# CITY OF ALBUQUERQUE

Re: Tract H Sawmill
1921 Bellamah Ave NW
Traffic Circulation Layout
Engineer's Stamp 07-06-22 (J13-D017B)

Based upon the information provided in your submittal received 09-06-22, the above referenced plan cannot be approved for Building Permit until the following comments are addressed:

1921 BELLAMAH AVE NW ALBUQUERQUE, NM		DRAWN BY pm
	SITE PLAN		DATE 8-1-22
 7-6-22 RONALD R. BOHANNAN P.E. #7868			SHEET # SP-1
	5571 MIDWAY PARK PL NE ALBUQUERQUE, NEW MEXICO 87109 (505) 858-3100 www.tierrowestllc.com		JOB # 2022047

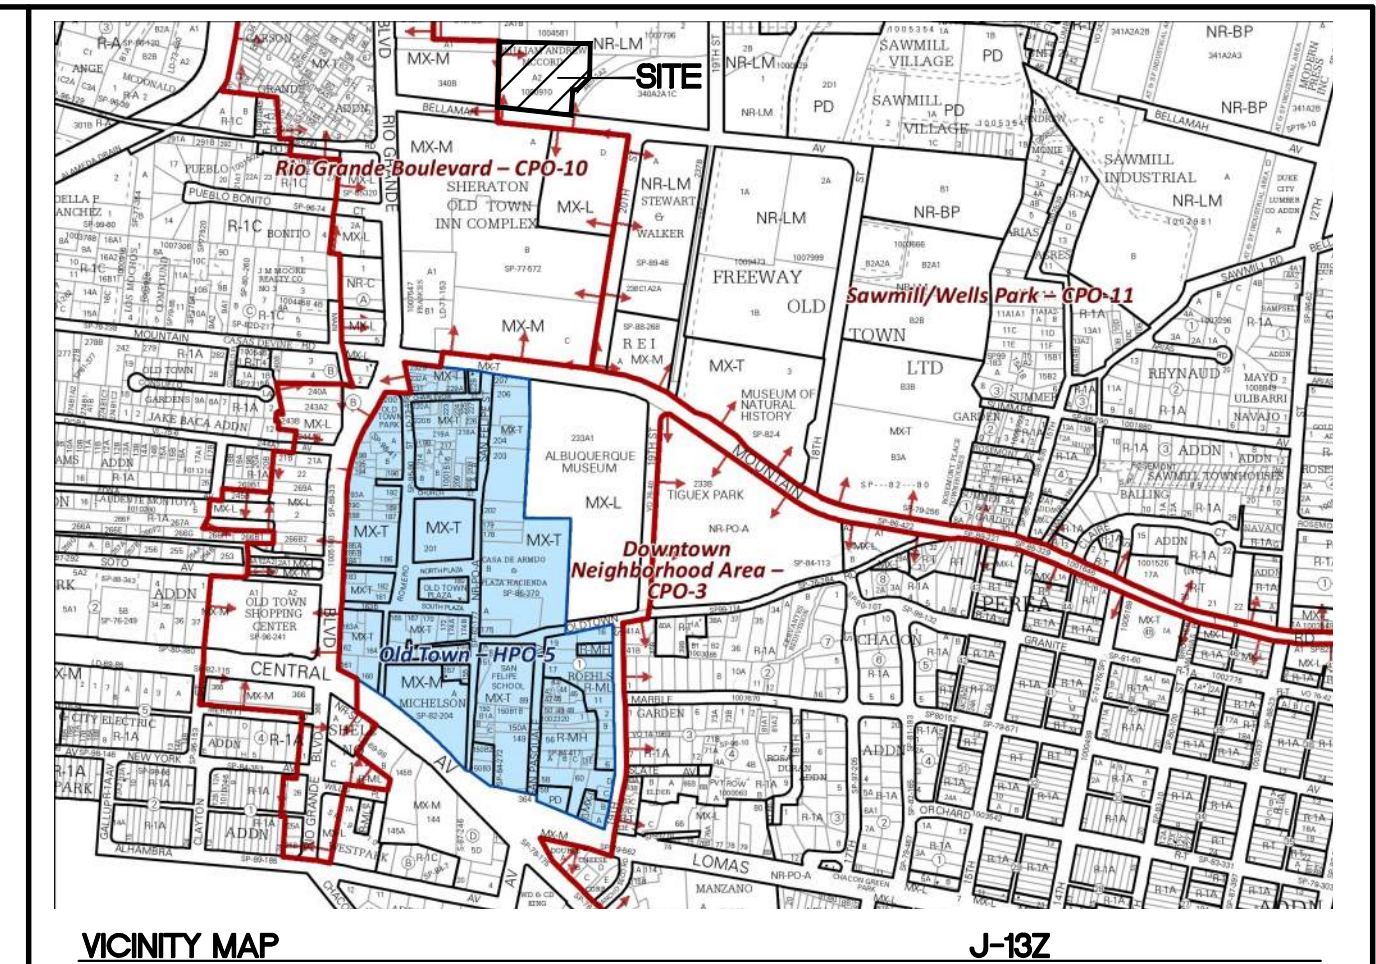
- Site Access: please provide Curb Return design for the driveways access off Bellamah Ave. and reference COA std dwg. 2426. Also, the One Way drive (Exit Only) shall have "Do Not Enter" signage and pavement marking. Please provide details for signage and pavement marking. Please note that the GIS shows there are two existing curb return driveways access.

- 2. Please reconfiguration parking spaces layout. The parking layout should provide continuous flow of traffic through the lot.
  - 3. ADA curb ramps must be updated to current standards and have truncated domes installed.

- 4. Per the IDO, a 6 ft. wide ADA accessible pedestrian pathway is required from the public sidewalk to the building entrances. Please clearly show this pathway and provide details.

- 5. Per DPM, a 6 ft. wide ADA accessible pedestrian pathway is required from the ADA parking stall access aisles to the building entrances. Please clearly show this pathway and provide details.

- 6. Define ADA pathways by labeling of ramps, flush pavement, dimensioning of pathways, doorways, etc.
  - 7. ADA accessible pedestrian pathway should not be placed behind parking space or adjacent to a vehicular way. Vehicle and pedestrian/wheel chair conflicts should be avoided as much as possible.

- 8. Parking areas shall have barriers to prevent vehicles from extending over public sidewalk, public right-of-way, or abutting lots.
  - 9. Refuse vehicle maneuvering shall be contained on-site. The refuse vehicle shall not back into the public right of way. provide a copy of refuse approval.

- 11. It is not apparent what type of pavement surface is being proposed. A hard driving surface will be required as part of this proposed project for parking area and drive aisles.

- 12. Please specify the City Standard Drawing Number when applicable.
- 13. Add a note stating "All broken or cracked sidewalk must be replaced with sidewalk and curb & gutter." A build note must be provided referring to the appropriate City Standard drawing.
